1.1.1 Velocity Transport Planning (VTP) has been appointed by Firethorn Trust (the Applicant) to provide highways and transport planning advice for an outline planning application relating to the development of up to 530 dwellings on land which forms part of the North West Bicester Eco Town development (Policy Bicester 1 of the adopted CDC Local Plan), located in Oxfordshire.

1.1.2 The Proposed Development description for the outline planning application, planning reference: 21/01630/OUT, is as follows:

# TECHNICAL NOTE: RESPONSE TO OCC COMMENTS

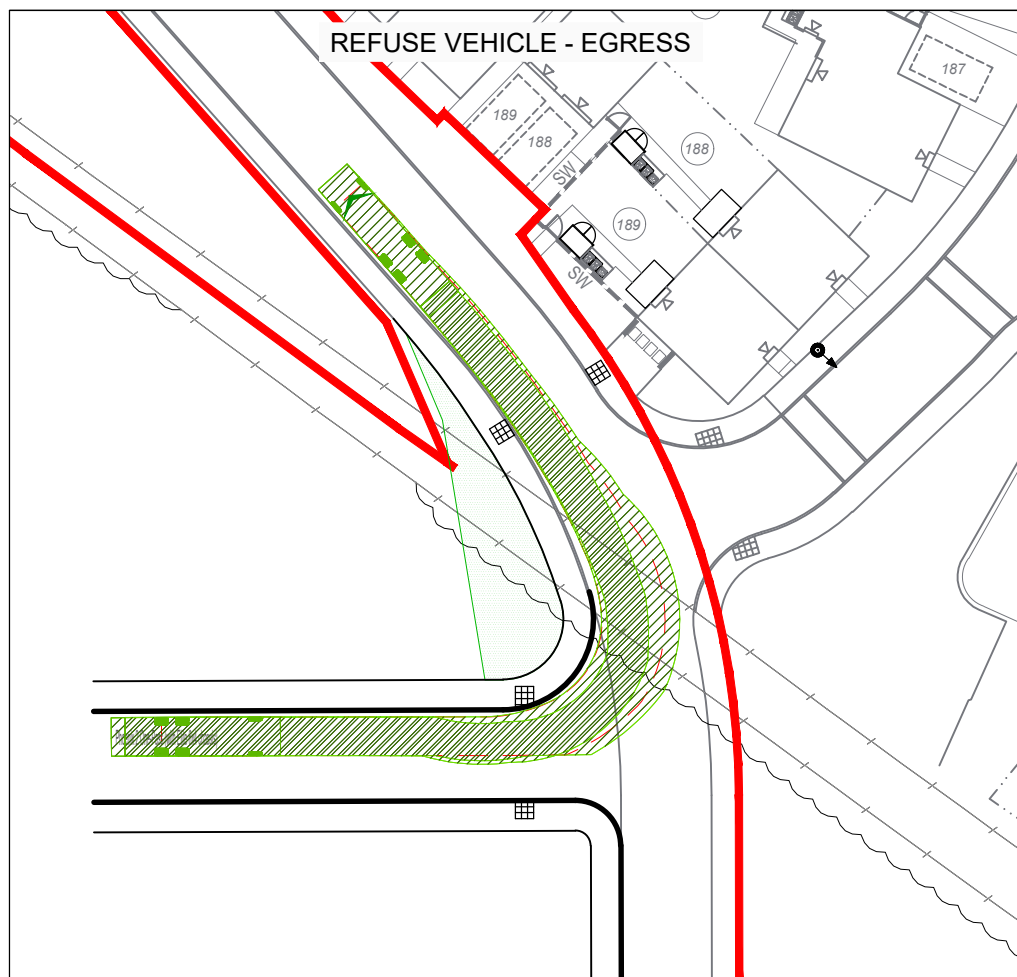
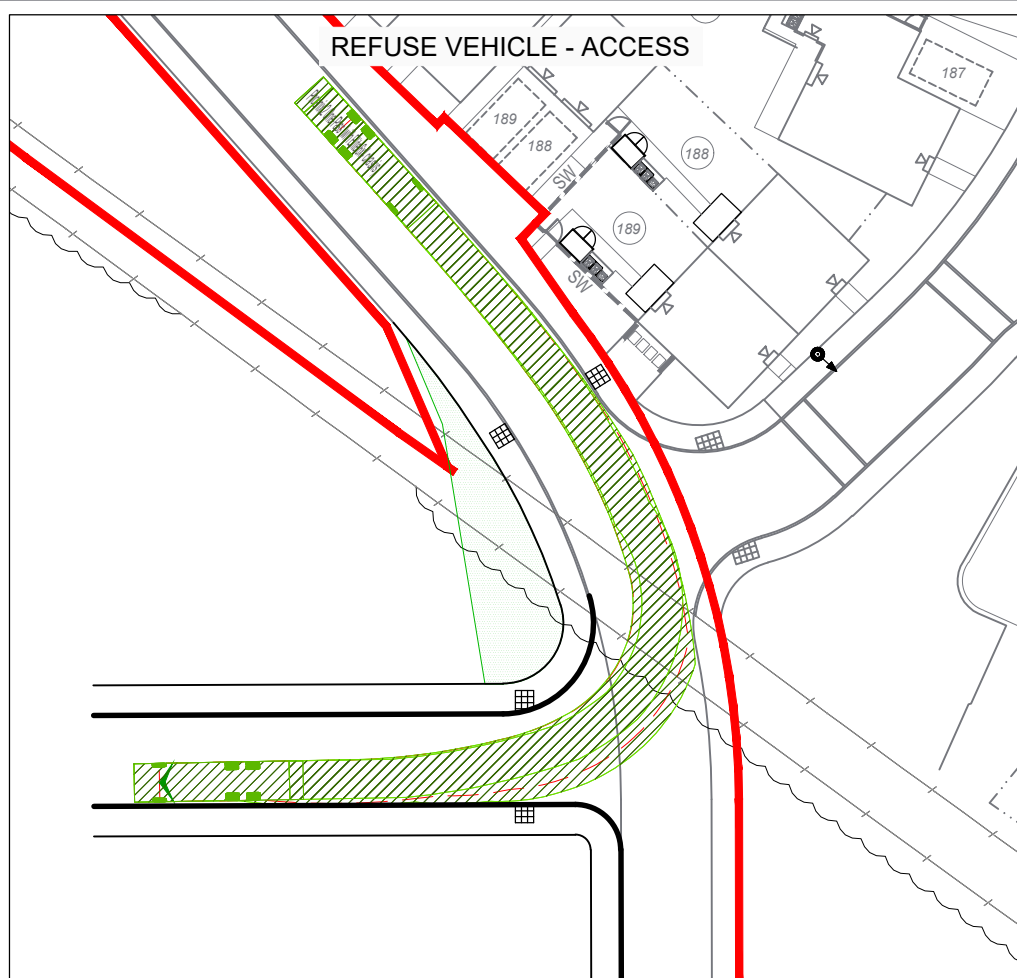
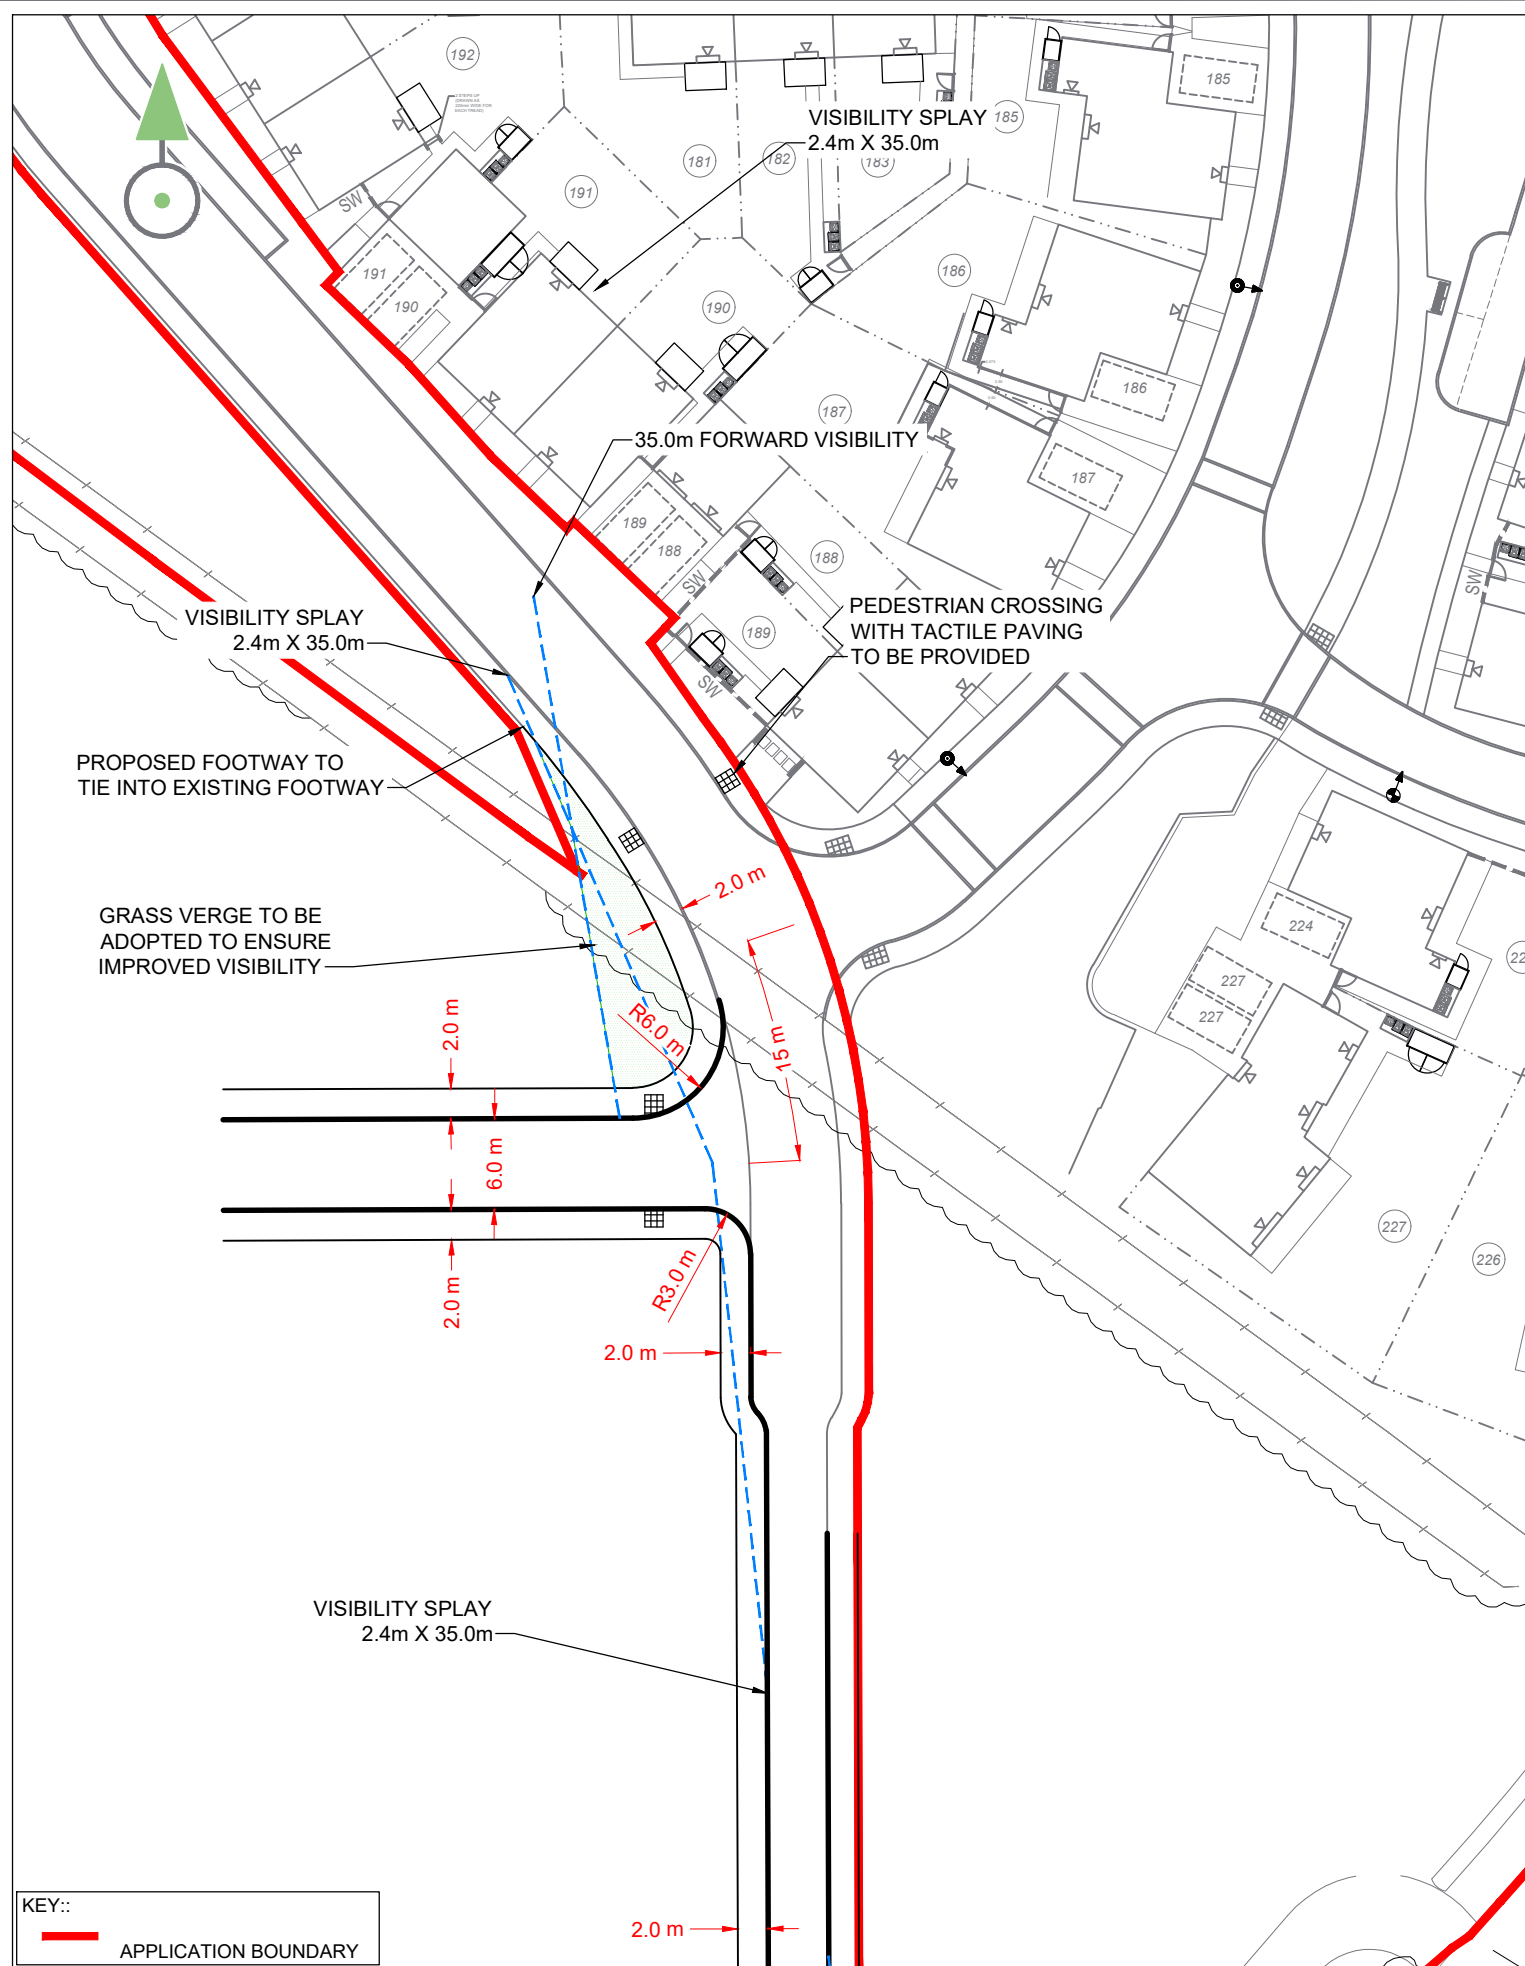
3.2.1 OCC requested that an updated Site Access Plan be presented for Site Access A – to the eastern parcel, which would identify the required works to deliver this access arrangement if Site Access B – to the western parcel south of the bus gate were to be excluded.

3.2.2 VTP Drawing 4600-1100-T-040 Rev A presents this arrangement and identifies that there will be a need to realign the existing kerb on the western side of the Spine Road in order to facilitate the swept path of a large refuse vehicle as it turns right towards the access road to the eastern parcel. Suitable visibility splays and footway provisions are identified on the updated VTP Drawing, a copy of which is included at **ATTACHMENT B**.
